DRB Application No.: 05DRB-00792 (P&F)  
Project Name: TANNEHILL-TAYLOR ADD.  
Agent: Wayjohn Surveying

WAYJOHN SURVEYING INC agent(s) for HARDEN ENTERPRISE LLC request(s) the above action(s) for all or a portion of Tract(s) A, **TANNEHILL-TAYLOR ADDITION**, zoned C-2 community commercial zone, located on MONTGOMERY BLVD NE, between EUBANK BLVD NE and MORRIS ST NE containing approximately 4 acre(s). [REF: 02DRB00844] (G-21) **PRELIMINARY AND FINAL PLAT APPROVED AND SIGNED OFF BY THE BOARD.**

RE: Tract A, Tannehill-Taylor Addition/minor plat

INDEXING INFORMATION FOR COUNTY CLERK OWNER: HARDEN ENTERPRISE LLC LOCATION: SEC. 4 T.10 N., R.4 E., N.M.P.M. TANNEHILL-TAYLOR ADDITION	DRAWN: T R J	SCALE: 1" = 50'	FILE NO. SC-10-07-2004
	CHECKED: T D J	DRAWING NO. SC100704.DWG	10 DEC 2004 SHEET 2 OF 2

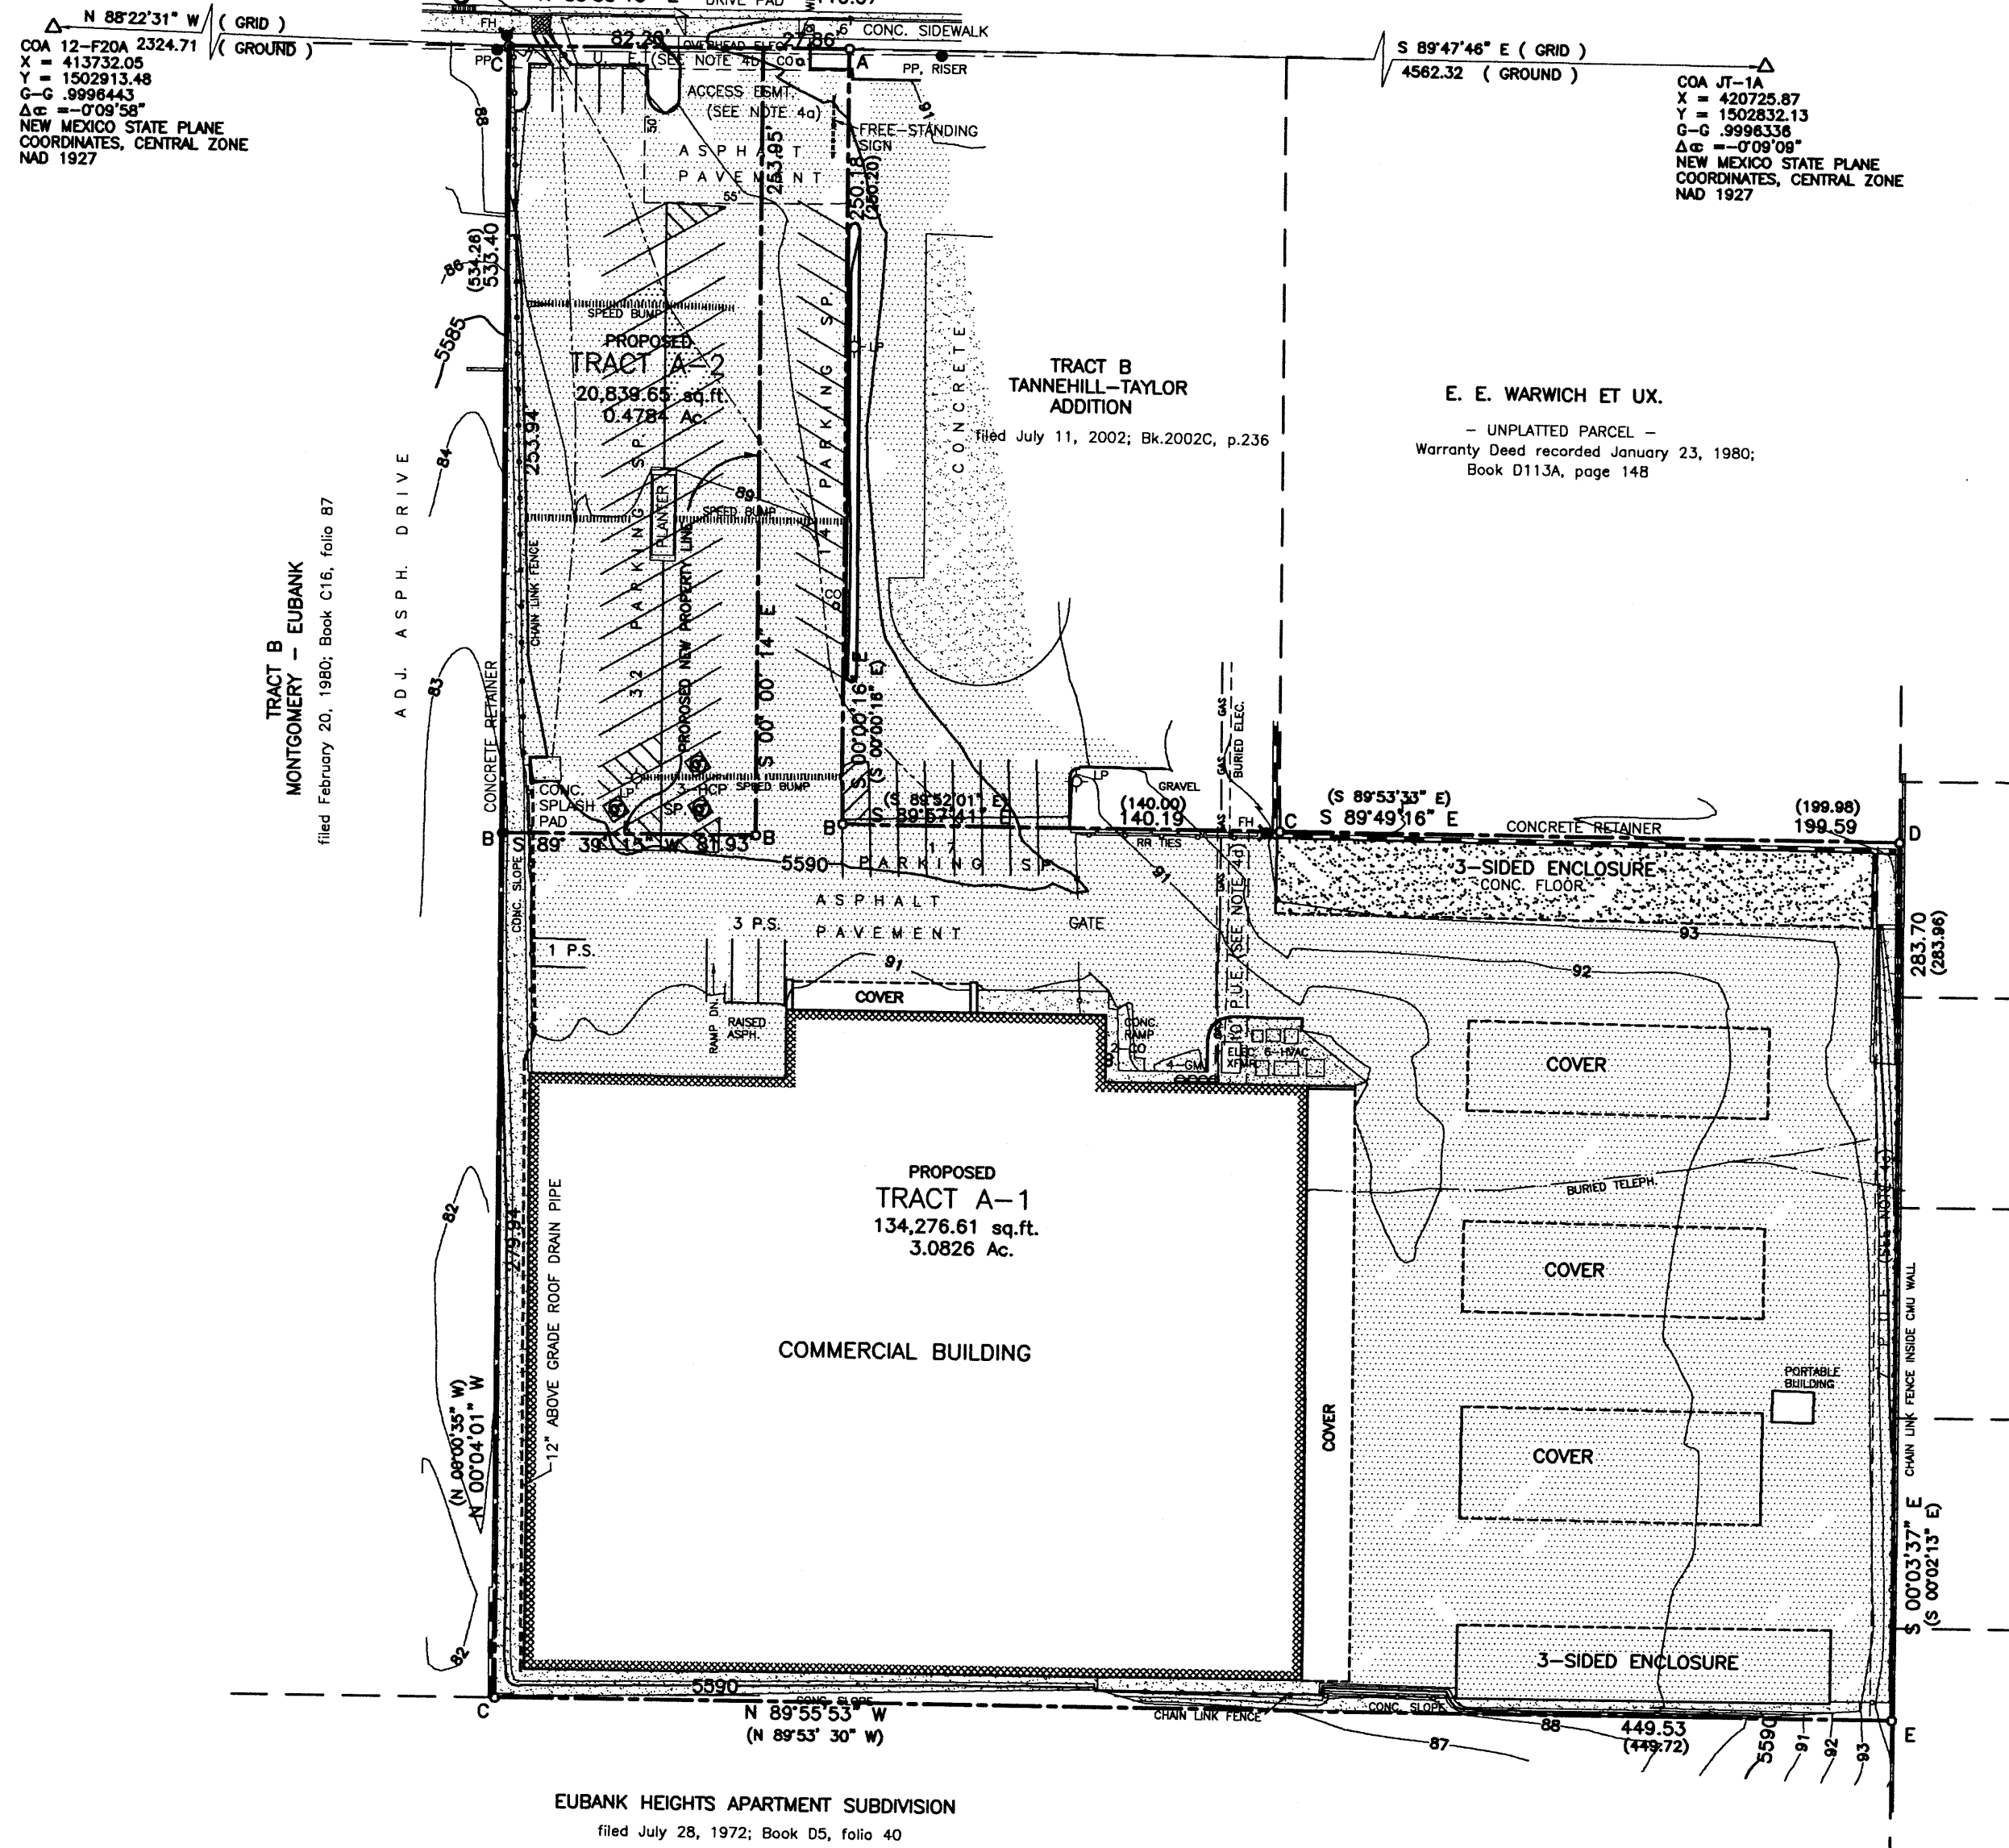
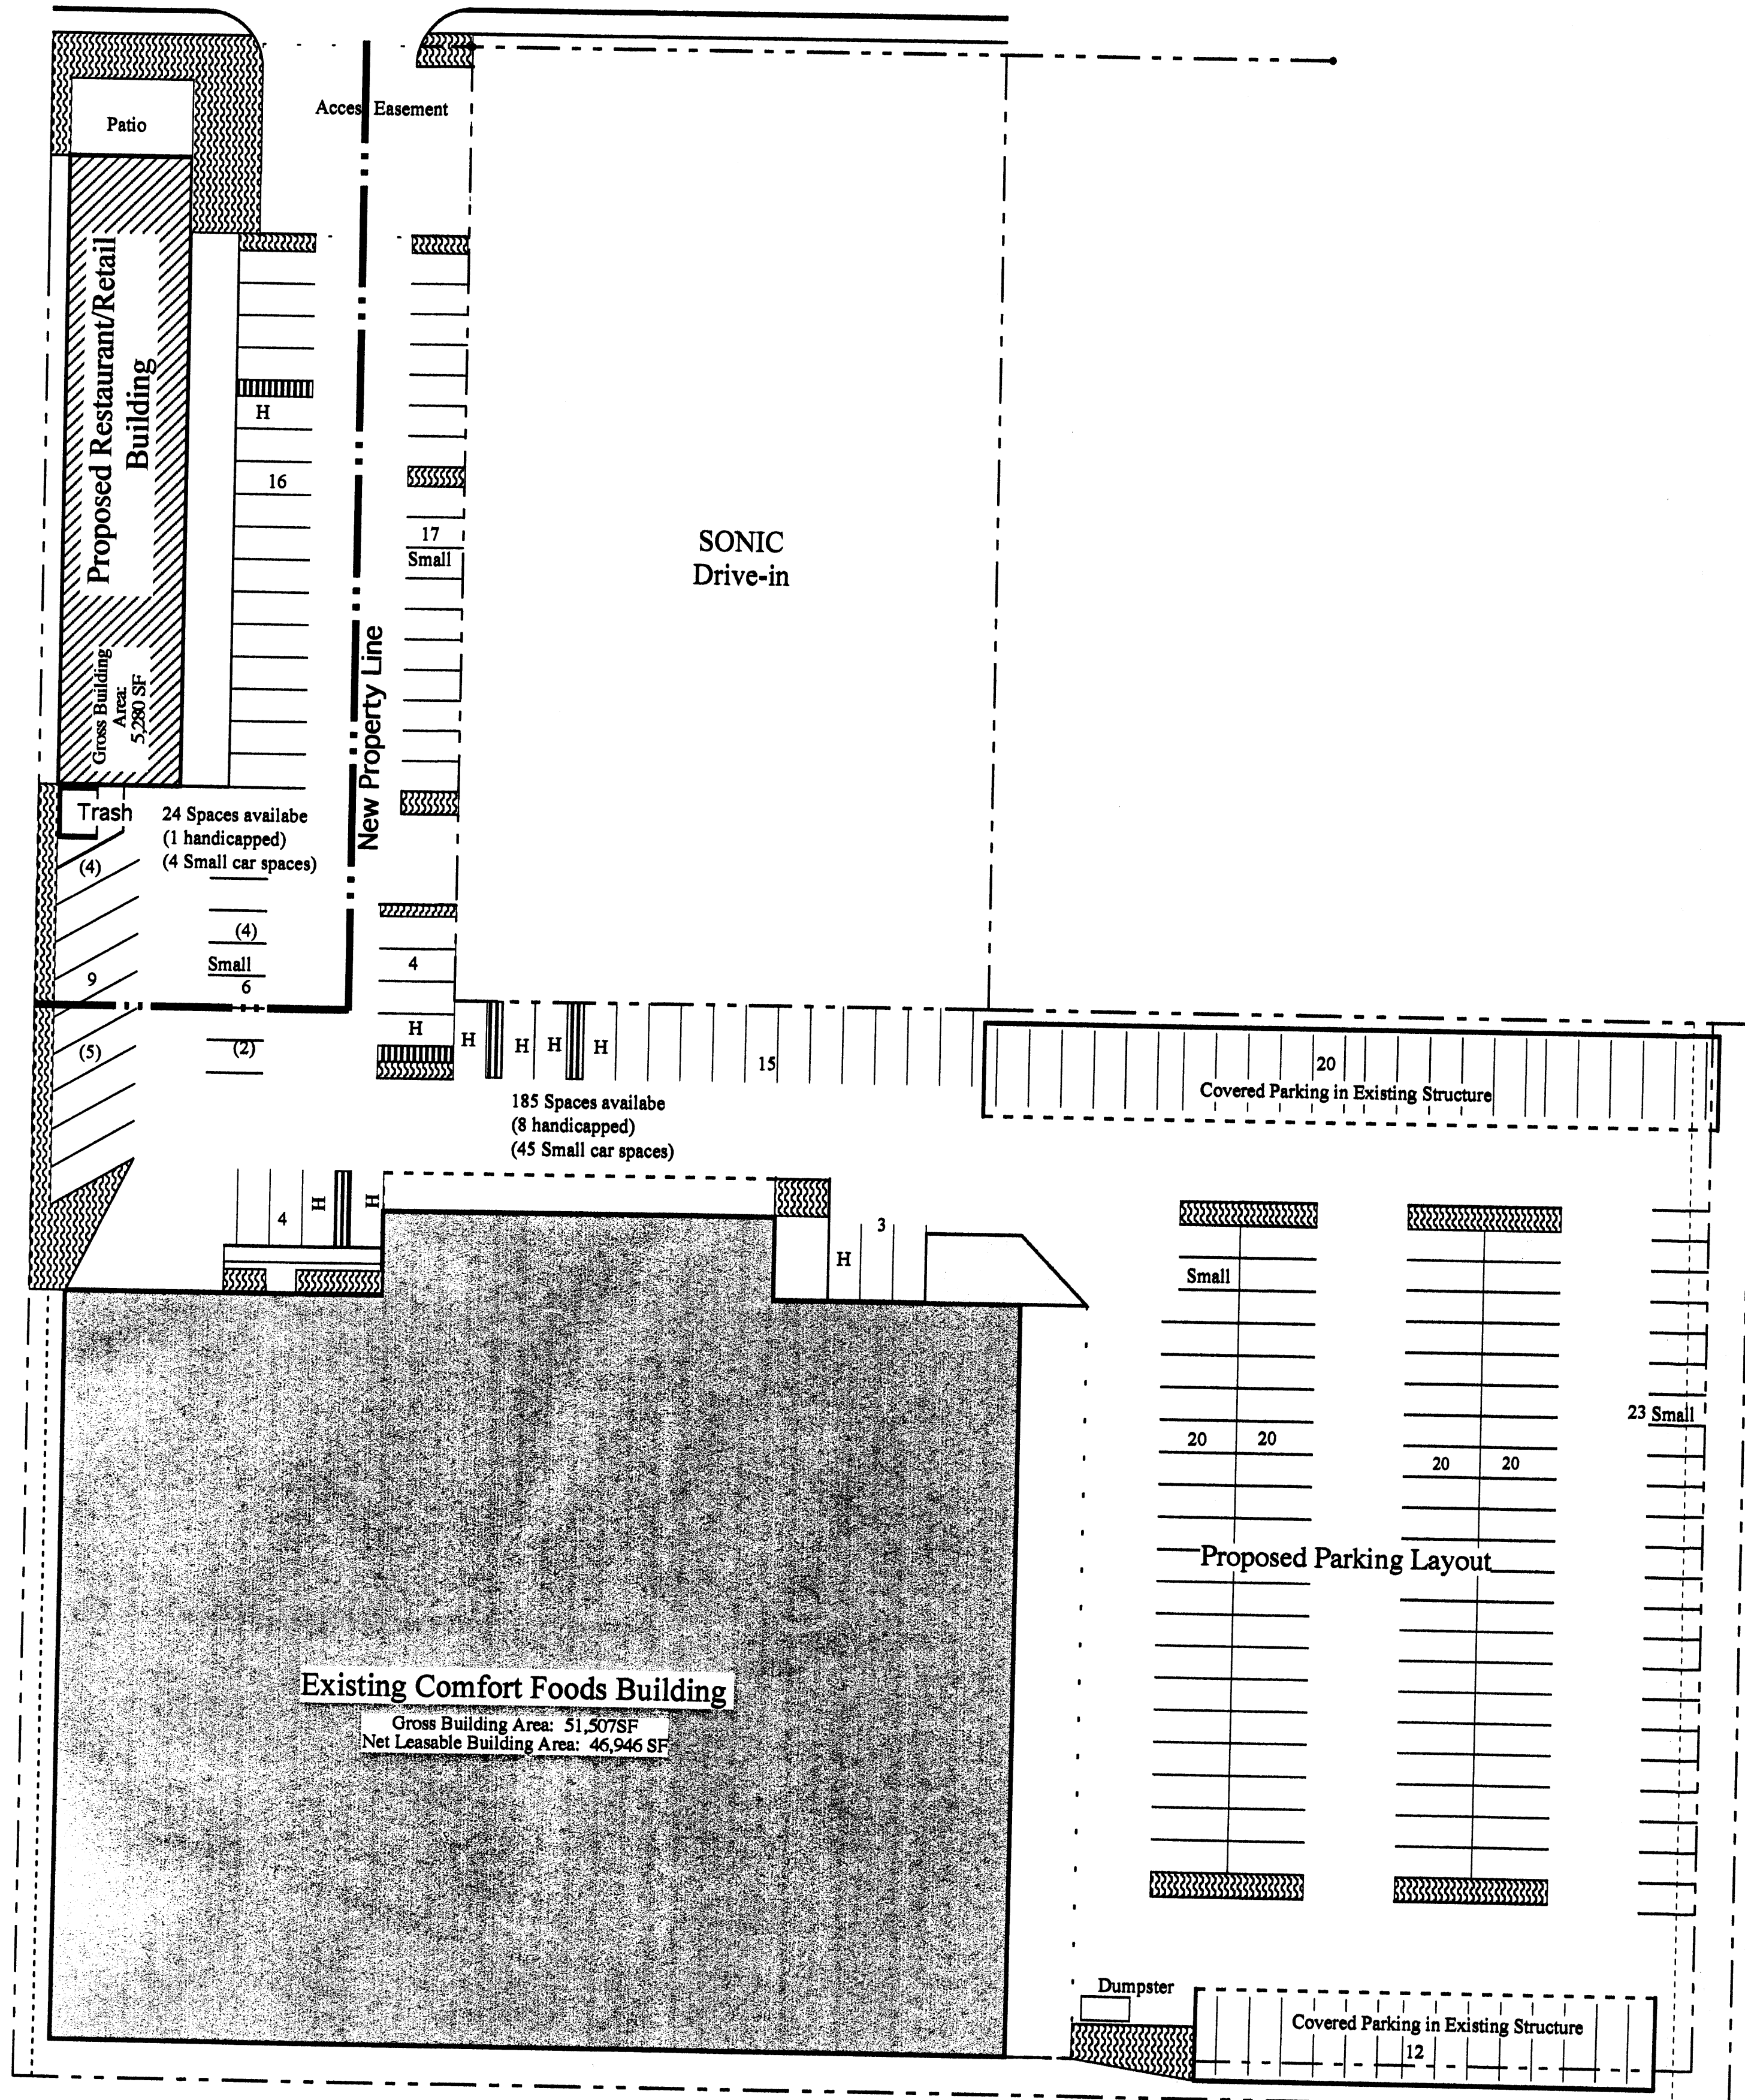
Cross-lot drainage easement required.
